TECHNICAL NOTE

LAND AT BURDELL ROAD, YAPTON, WEST SUSSEX RESIDENTIAL DEVELOPMENT

Client: Driftstone Homes Ltd
Reference: 6145

Date: July 2021

Drawing Status	FINAL		
Client	Driftstone Homes		
Project	Burdell Road, Yapton		
Drawing Title	Access Overview and Visibility Splays		
Scale	1:250	Date	July 21
Drawn By	SMO	Checked By	ALB
Drawing No.	2020-6145-001		Rev.
		I

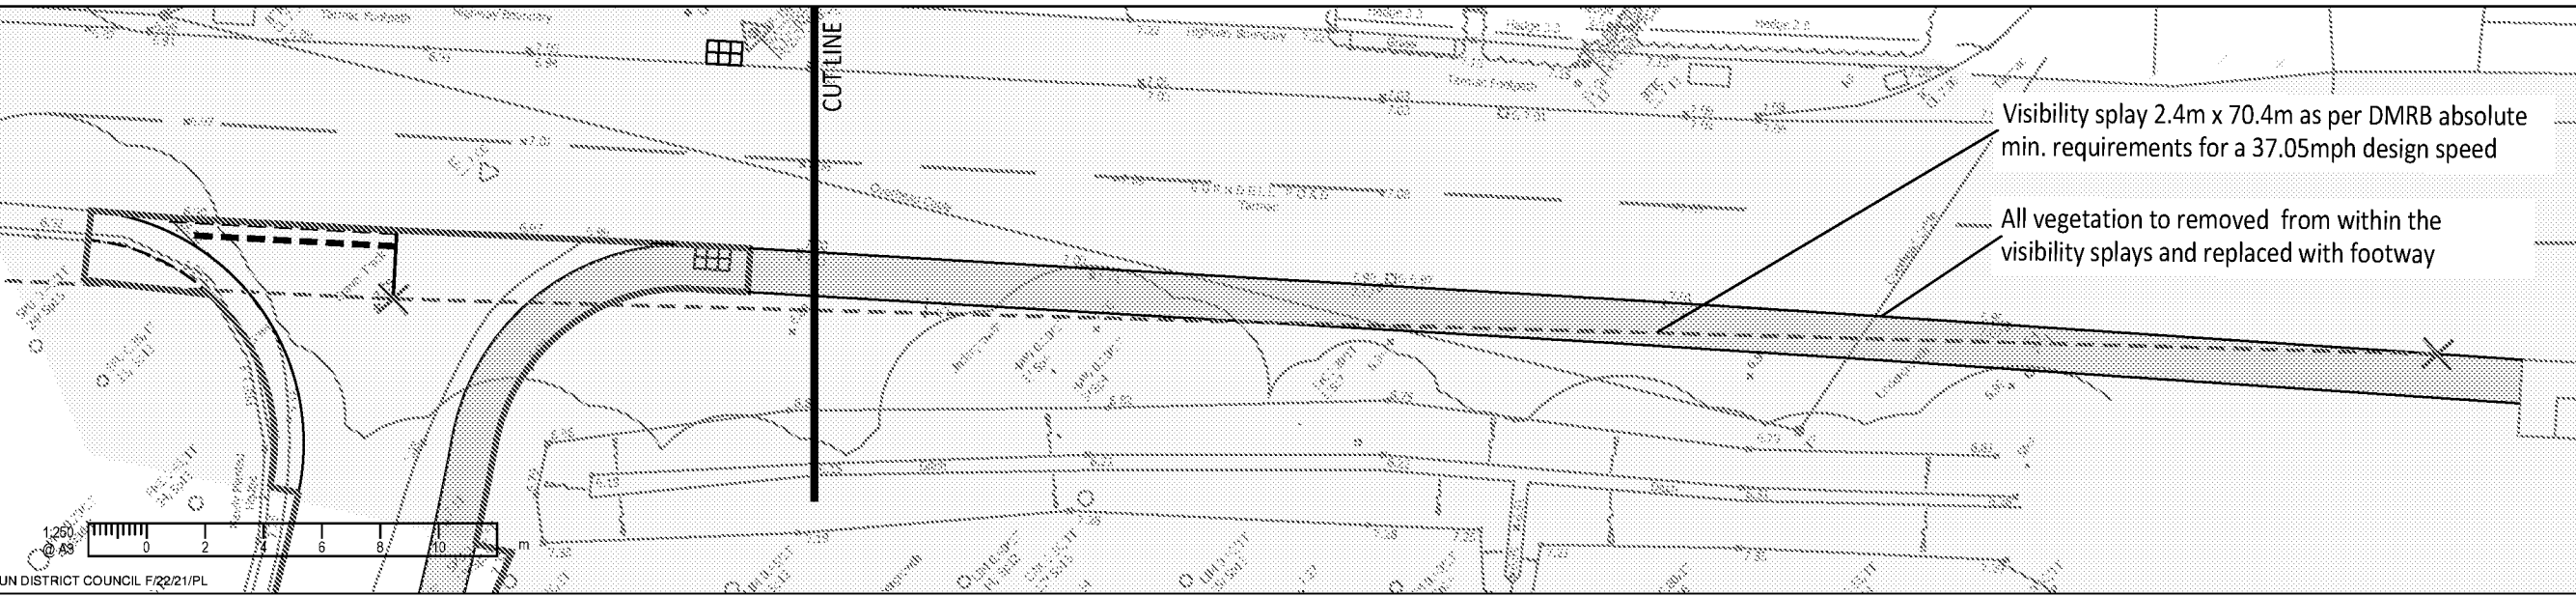
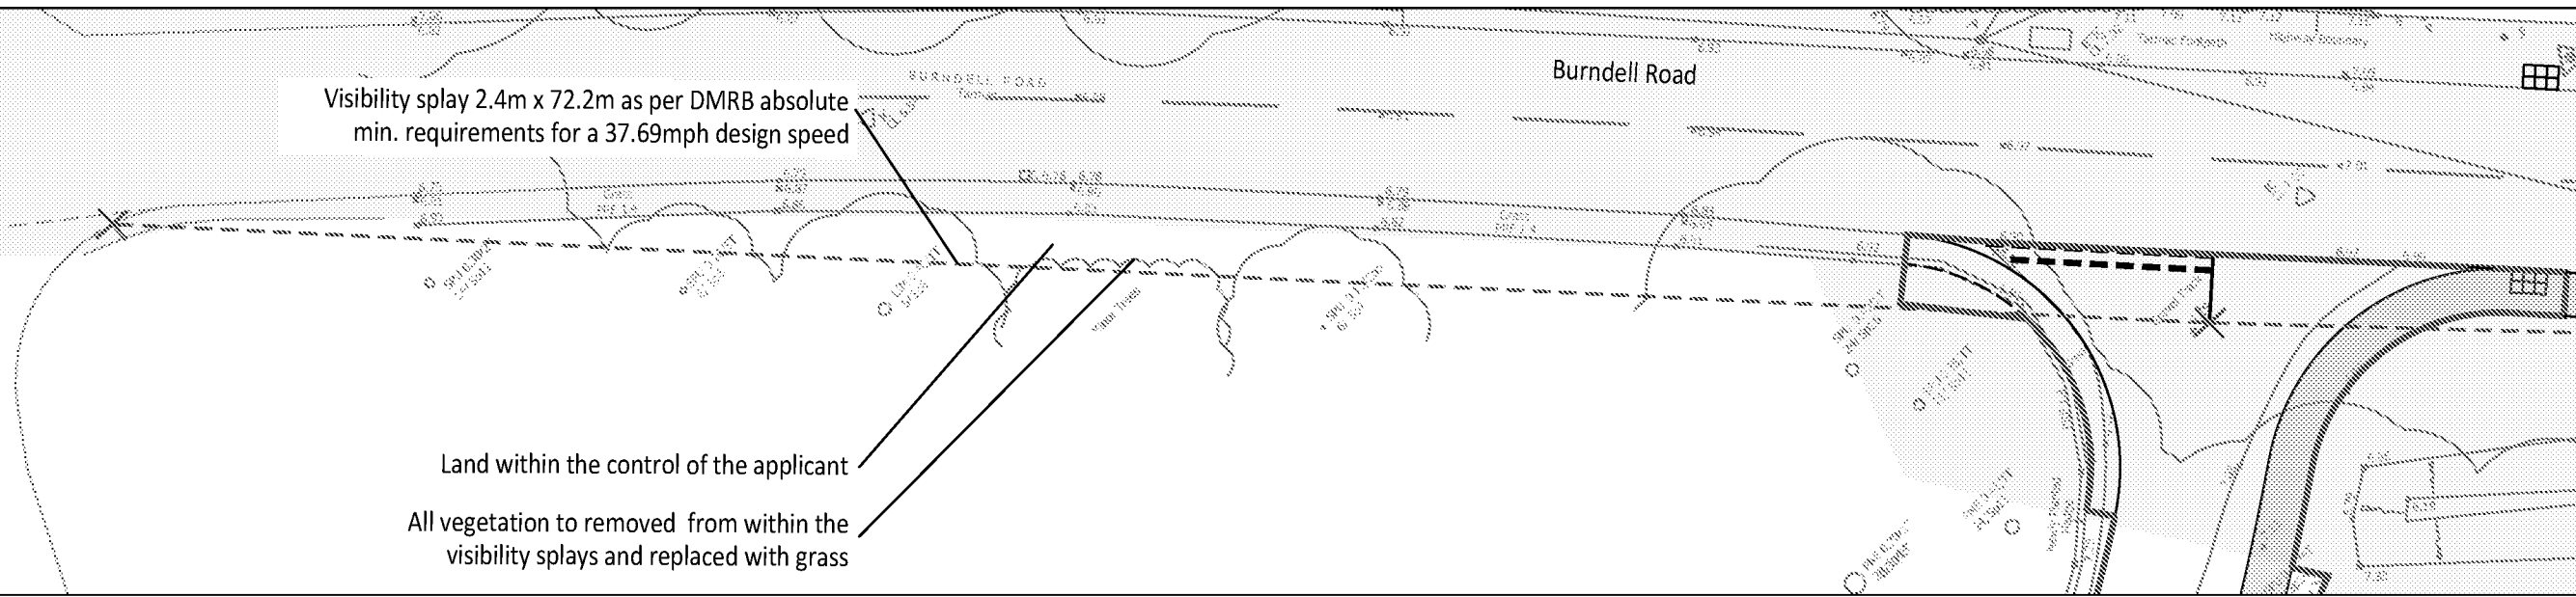
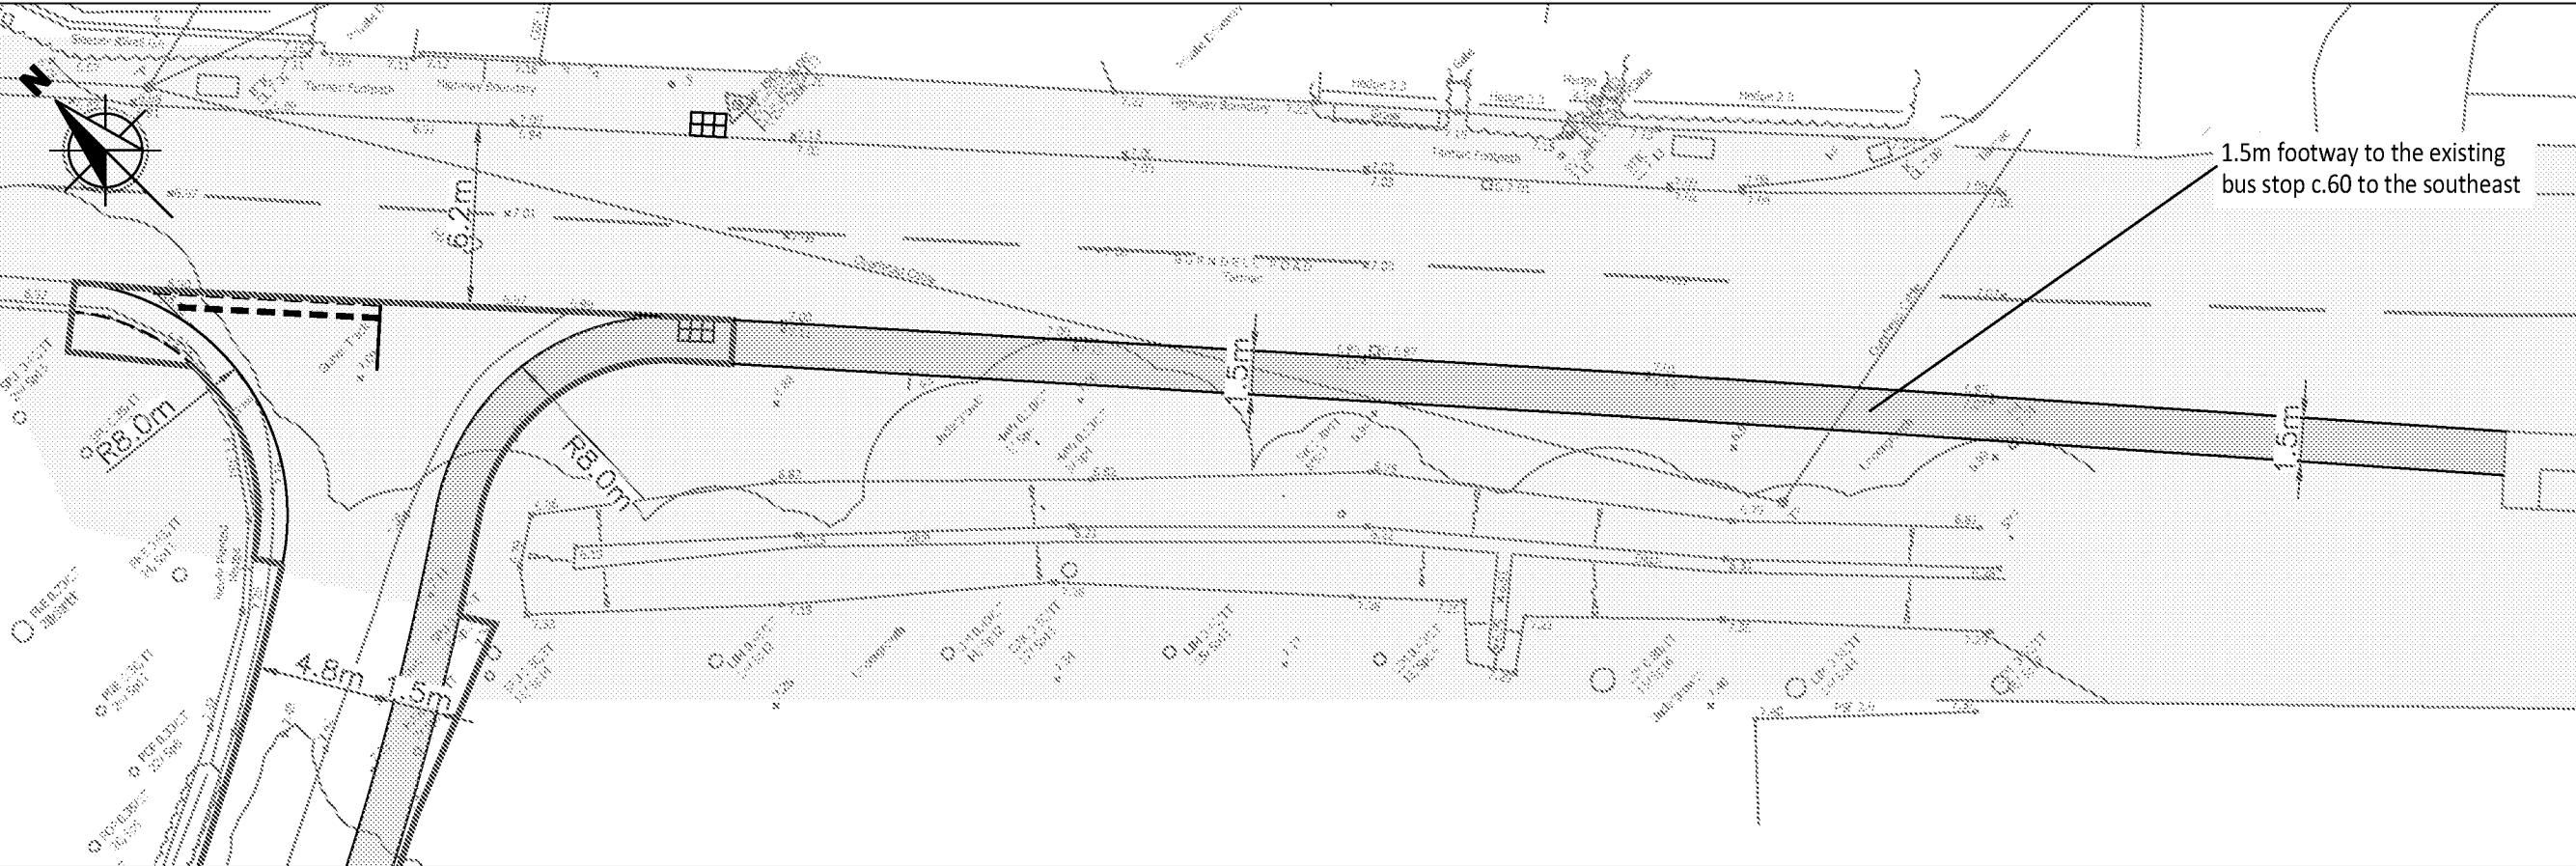
"ATC surveys taken during lockdown periods are acceptable for use in calculating 85th percentile speeds and concurrent visibility splay requirements but should not be used for traffic volume counts. The TS has taken a different approach where splays concurrent to the speed limit of 30mph and to a maximum design speed of 60kph (37.3mph) have been demonstrated. As speeds could be varying and above 37.3mph a 7-day speed survey is required to ascertain the up to date 85th percentile speeds in either direction, in vicinity of the access, along with amended vehicle visibility and pedestrian forward visibility splays in accordance with these recorded speeds."

Locations: A – The access junction onto Burndell Road (Dwg. 2020-6145-001 Rev. H)

Summary: Risk of side impact collisions due to the visibility from the access road being obstructed by vegetation.

Although the post and rail fence will require removal, and the existing vegetation will be cut back, to obtain the visibility splay in both directions from the access road, the amount of overgrown vegetation present (brambles, nettles, low tree branches etc – see photos 1 and 2) will need constant maintenance to ensure that the visibility splays are not obstructed, especially to the south-eastern side of the access junction where approaching traffic will be closest to the give way lines as vehicles exit the development. Any obstruction to visibility is likely to increase the risk of side impact collisions at the access junction.

All vegetation, including low branches from adjacent trees, should be removed completely from within the proposed visibility splays, and replaced with either grass or a footway (to the south-east – see recommendation to problem 2.2).

- 2.2.2 The southbound design speed narrowly exceeds 60kph, a threshold at which DMRB CD 109 visibility requirements need to be considered. DMRB CD 109 identifies relaxations to the 'desirable minimum' stopping sight distance are permitted on Band B 60kph urban trunk roads. The low proportion of HGV's (<1%) on Burndell Road further supports relaxation from the desirable minimum as detailed in MfS 2 Section 10.1.

- 2.2.3 The secondary direction visibility splay has therefore been shown in accordance with DMRB 'absolute minimum' requirements equating to a stopping sight distance of 72.0m. The primary direction visibility splay has also been provided in accordance with DMRB absolute minimum requirements for consistency (although speeds on this approach direction fall below the DMRB 60kph threshold) equating to a stopping sight distance of 70.0m. The revised primary and secondary visibility splays are demonstrated in **Drawing 2020-6145-001**.
